Engineers Comments Regarding Surface Water Drainage

Application Reference:	P/36/26/DOC	Reviewer Reference:	EXT2/02
Planning Officer:	Hannah Kersley	Date of Review:	02/06/26
Site Name:	Land North of Sefter Road & 80 Rose Green Road Pagham		
Application Description:	Approval of details reserved by condition under P/134/16/OUT as amended by P/34/25/NMA relating to condition 13B- Surface Water Drainage.		
Assessment Number:	1 of 2

Drawing Title: As Built Storm
Water Drainage Survey -
Regis Park, Sefter Road,
Pagham, Bognor Regis, PO21
3EE - SHEET 2.

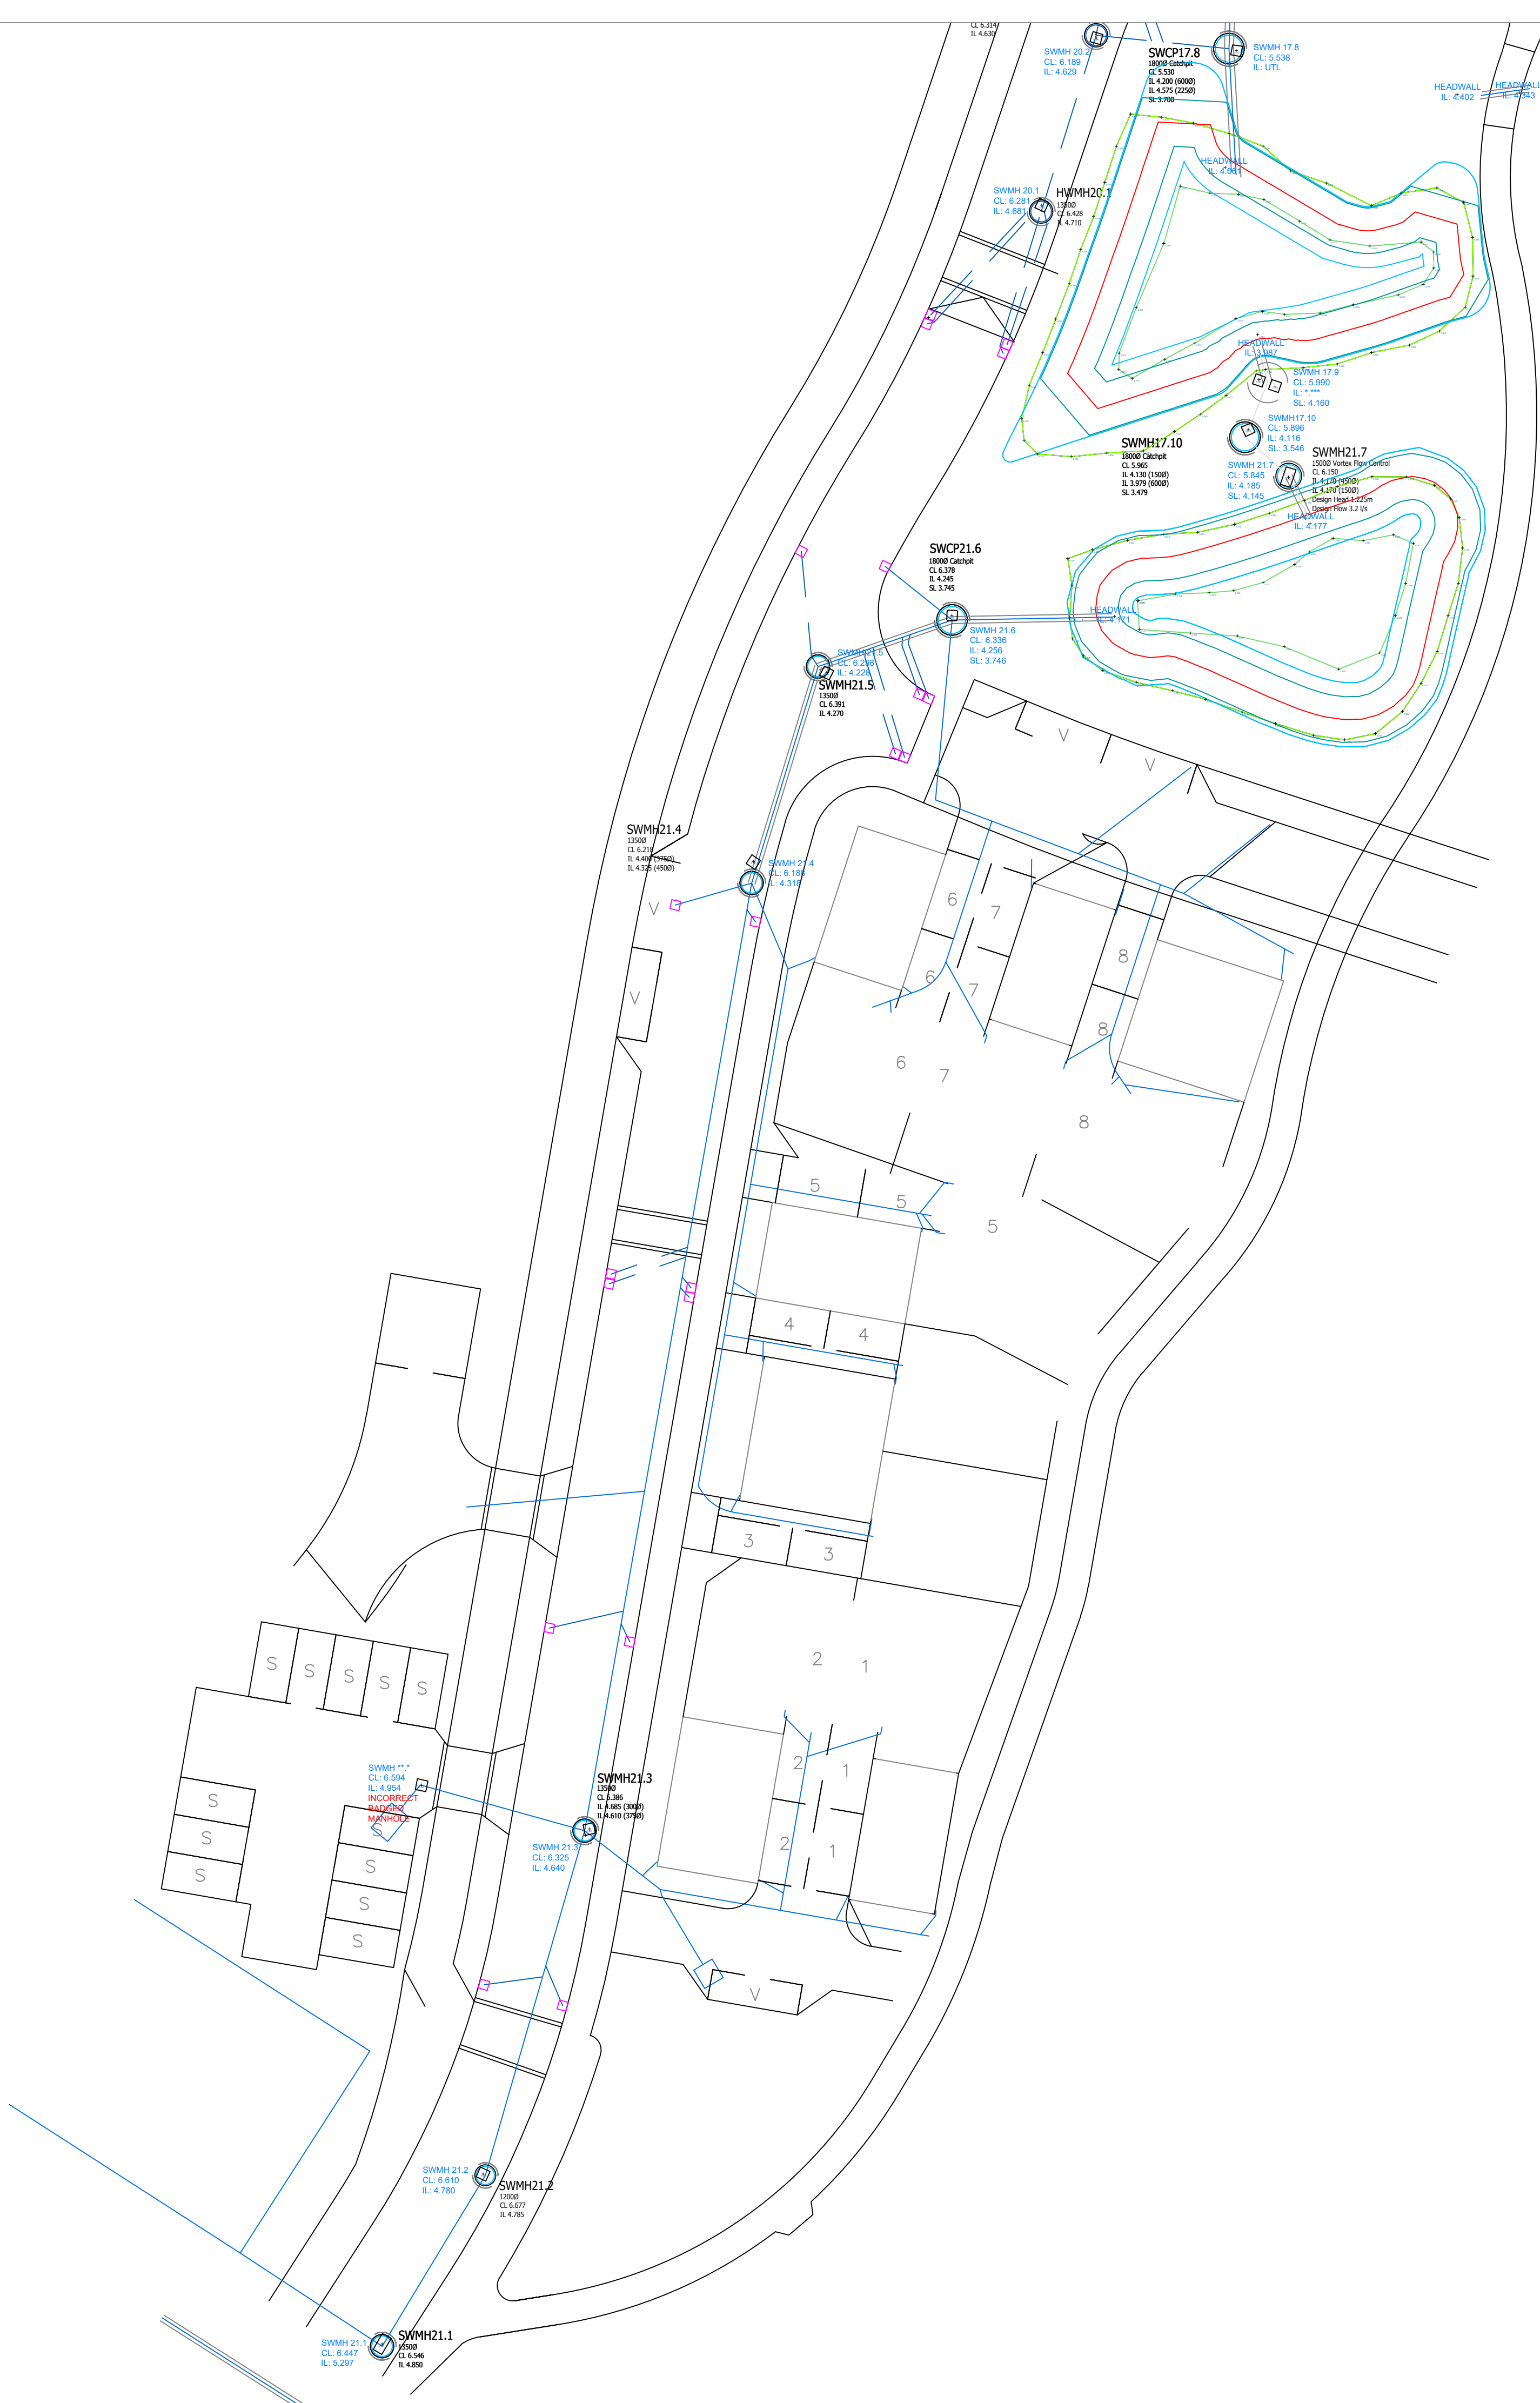
8.	Verification Report Contents: “As built’ Survey with drawings of suitable scaling, to include all relevant details discussed below” The as built survey is incomplete as it is missing information for some chambers and no levels are provided for the basins.

levels." The as built drawing confirm that some pipe invert levels are not as designed, this is not discussed in the report.				
10.	Verification Report Contents: "Commentary of the condition of all constructed components and compliance with the approved drawings". The commentary provided does not demonstrate that the SuDS features have been constructed correctly, other than what can be seen at surface level. Eg. it is not demonstrated that the cellular tanks have been installed to the correct size or level.

15.	As-Built Drawings and Topographic Survey Pipe diameters and materials are not shown				
16.	As-Built Drawings and Topographic Survey Finished levels and surface type is not shown for roads, footpaths, drives and parking areas. Finished floor levels are not shown

17.	As-Built Drawings and Topographic Survey Tank base levels, height, cover level and plan dimensions are not shown.				
18.	As-Built Drawings and Topographic Survey Permeable paving base levels, finished surface levels and depth of sub base are not shown

19.	As-Built Drawings and Topographic Survey Flow control internal chamber dimensions are not shown				
20.	Certification
